South Holland District Council

**Re: Reserved Matters Application for Residential Development of 60 Dwellings
Land Off Nightingale Way Sutton Bridge – H18-1167-19**

We refer to recent email communications and in particular your email dated 2nd January 2020 raising various comments and queries. This letter responds in detail to the points raised in the same order presented within your email.

FLOOR PLANS & ELEVATIONS
HOUSE CODE: 3bdd_A

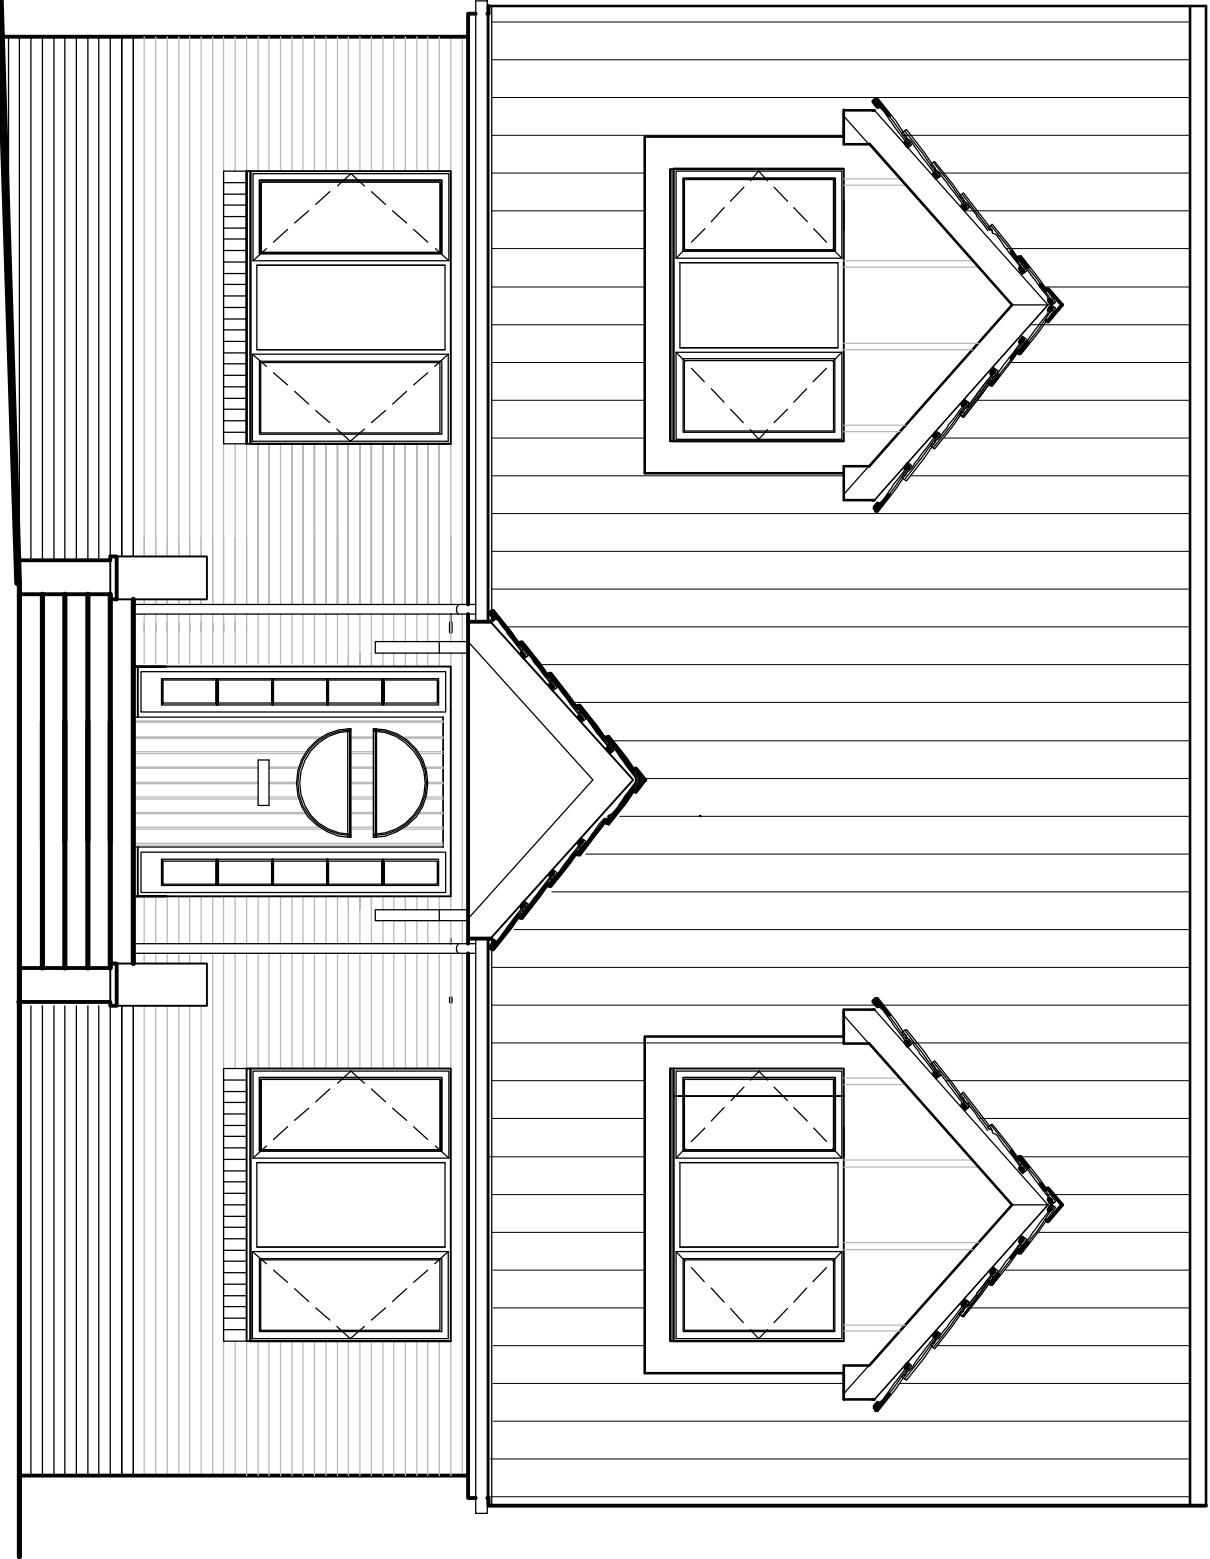
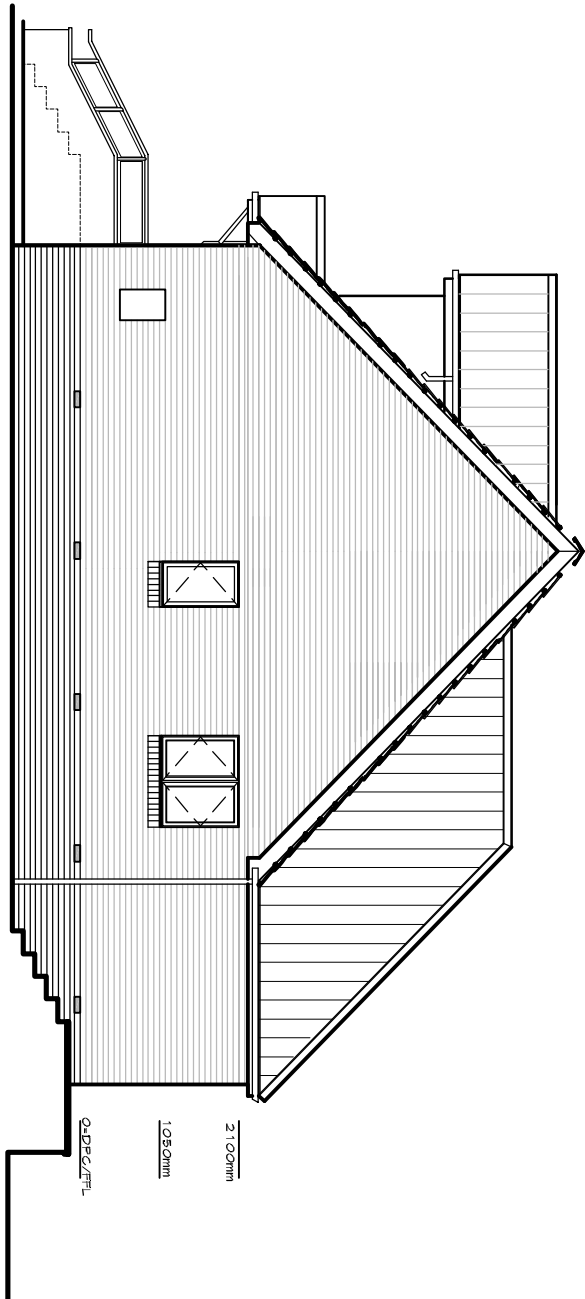
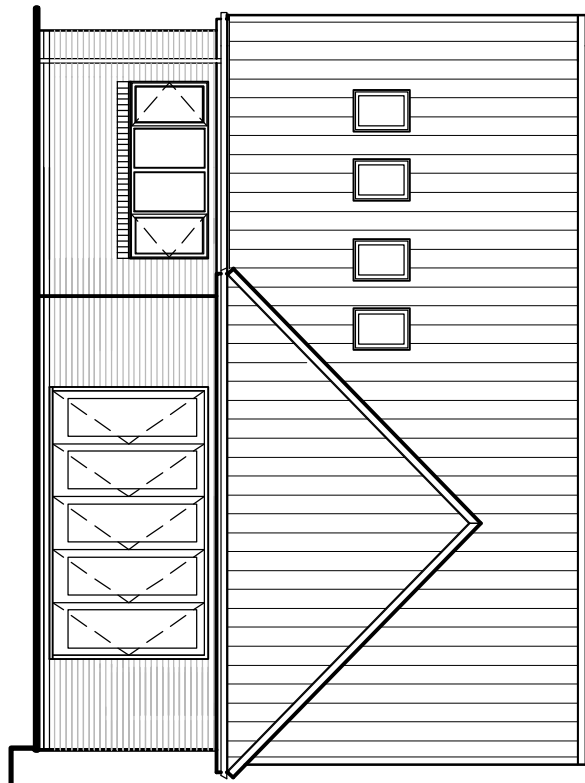
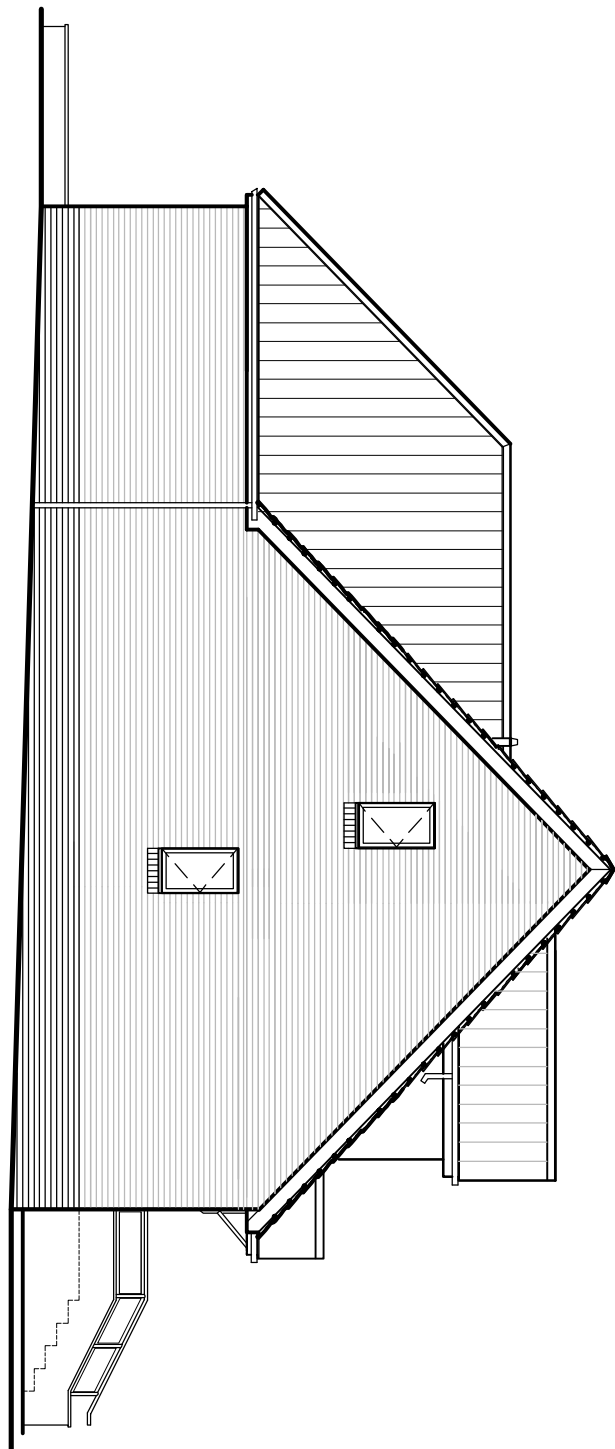
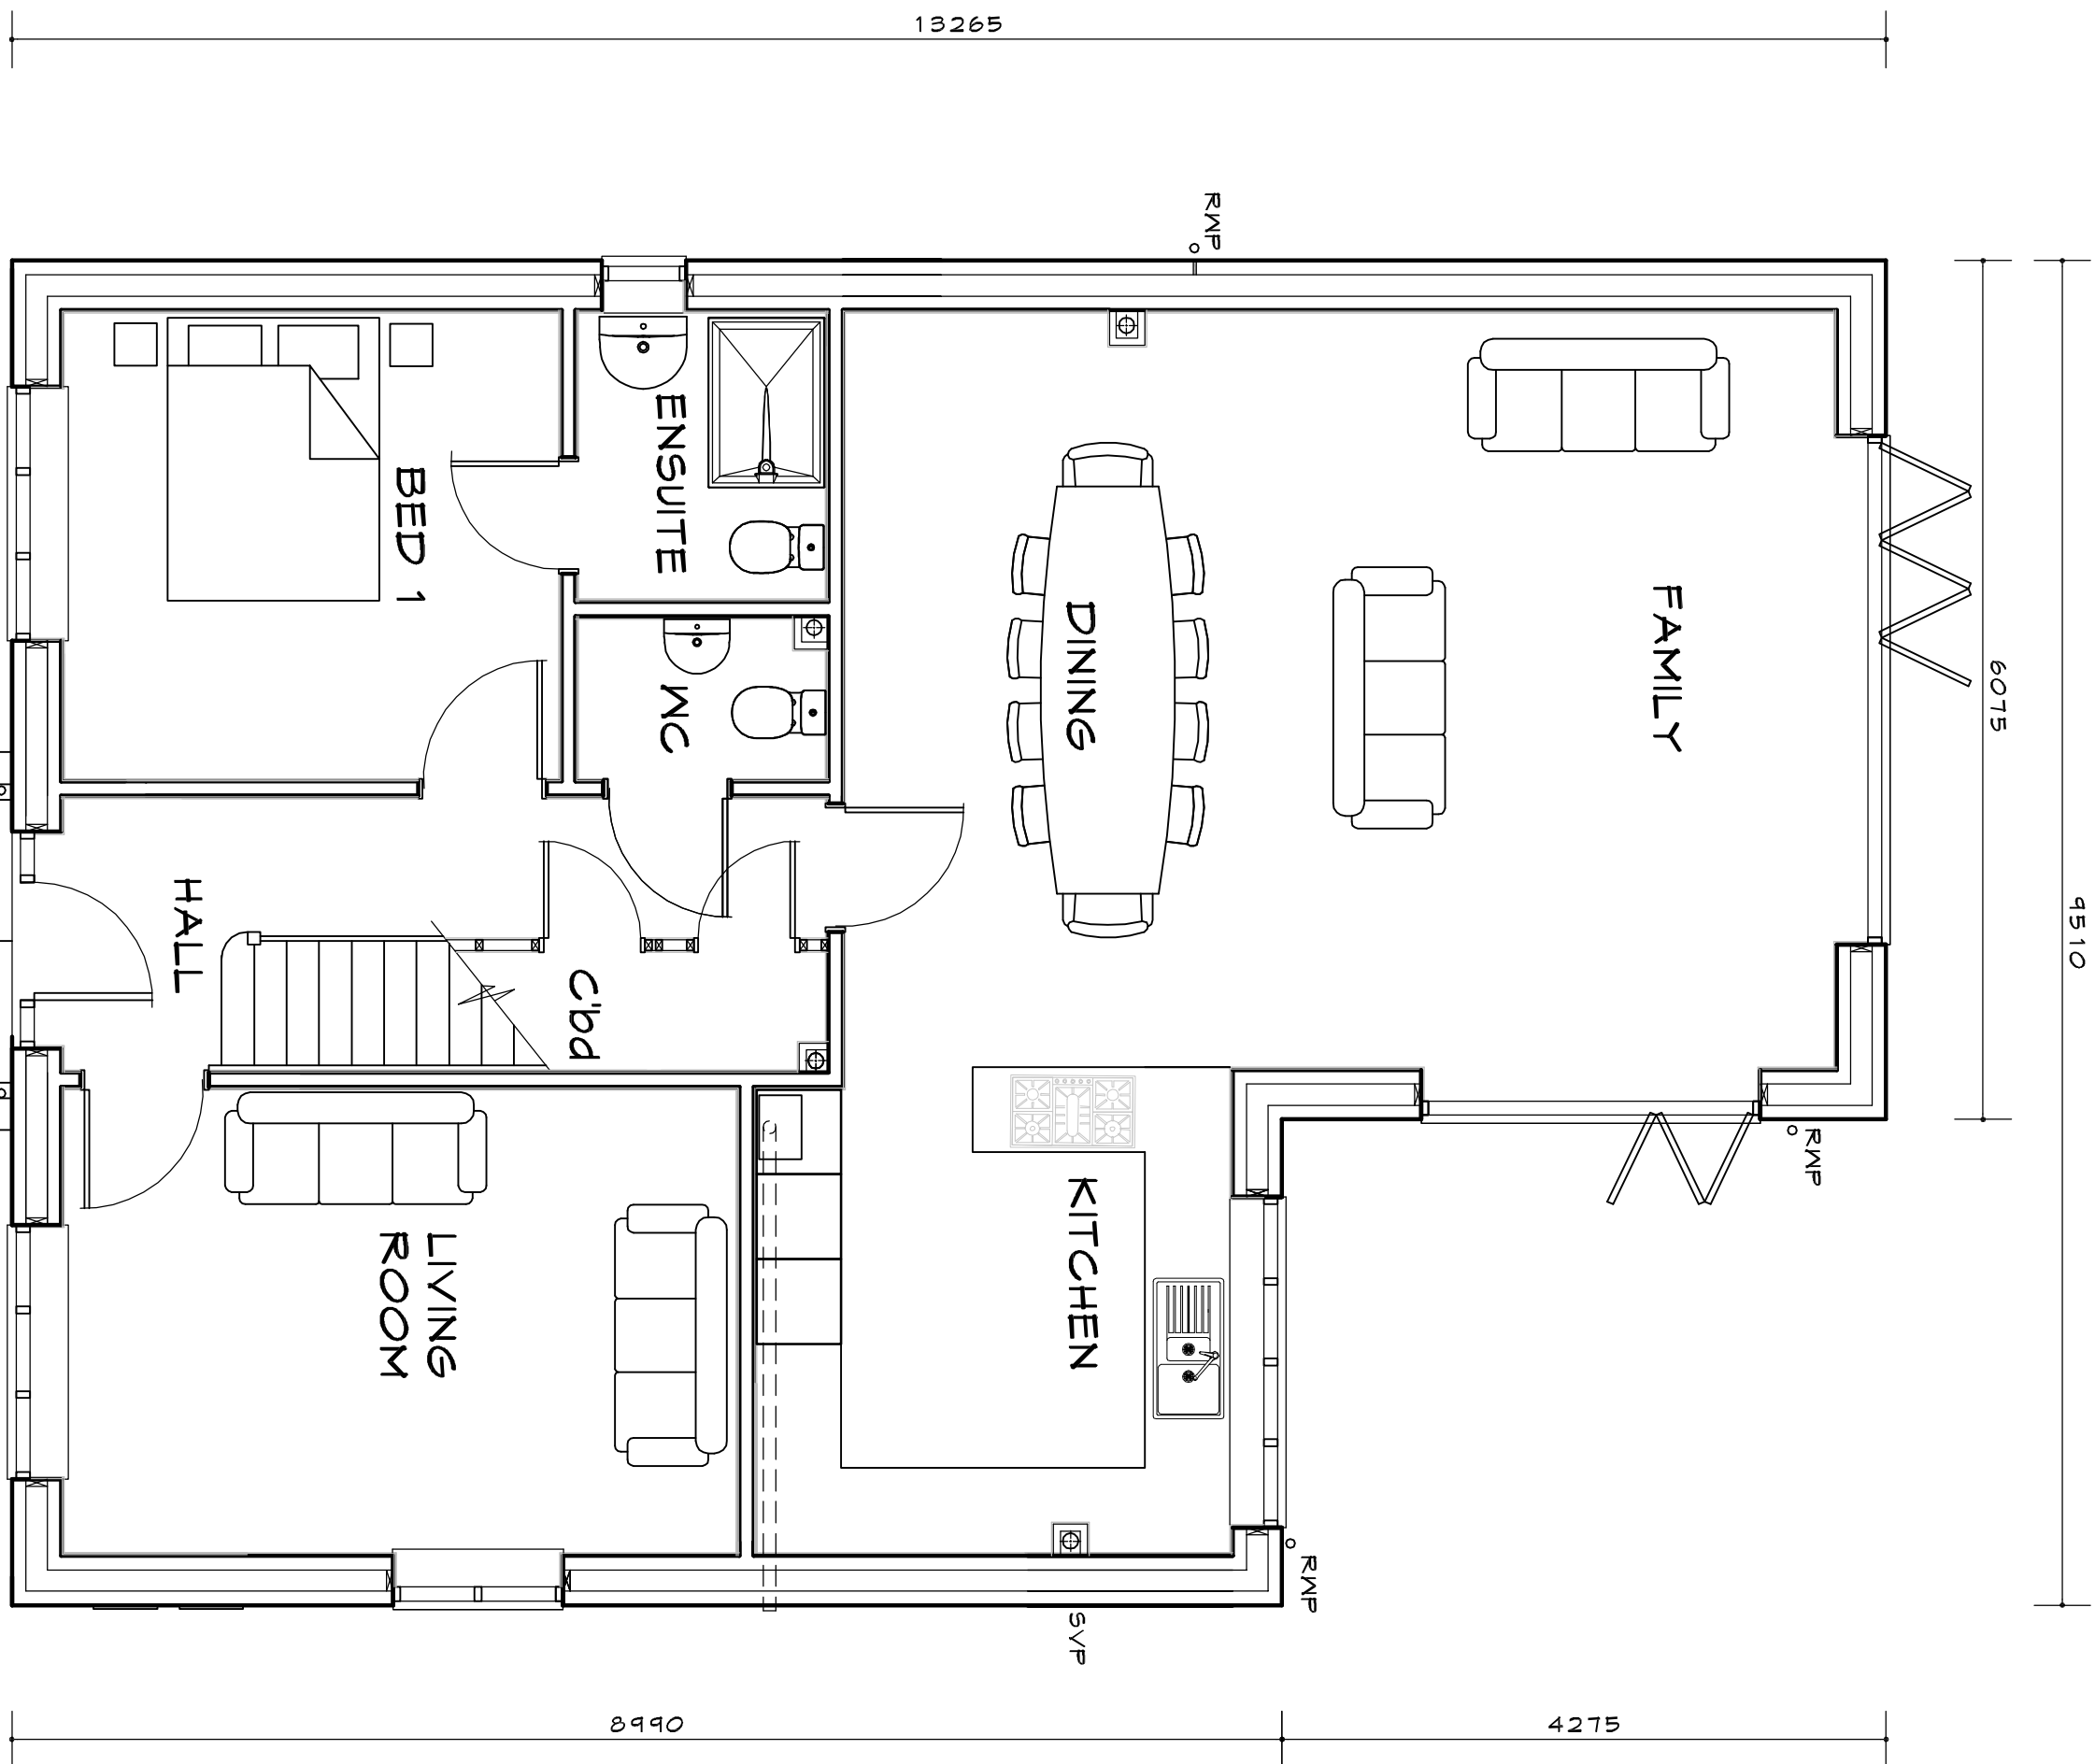
7.01 The discrepancies noted have been rectified and revised drawings are now enclosed for house designs 1b2s_A/2b2s_B, 3bdd_A and 3b2s_AA.
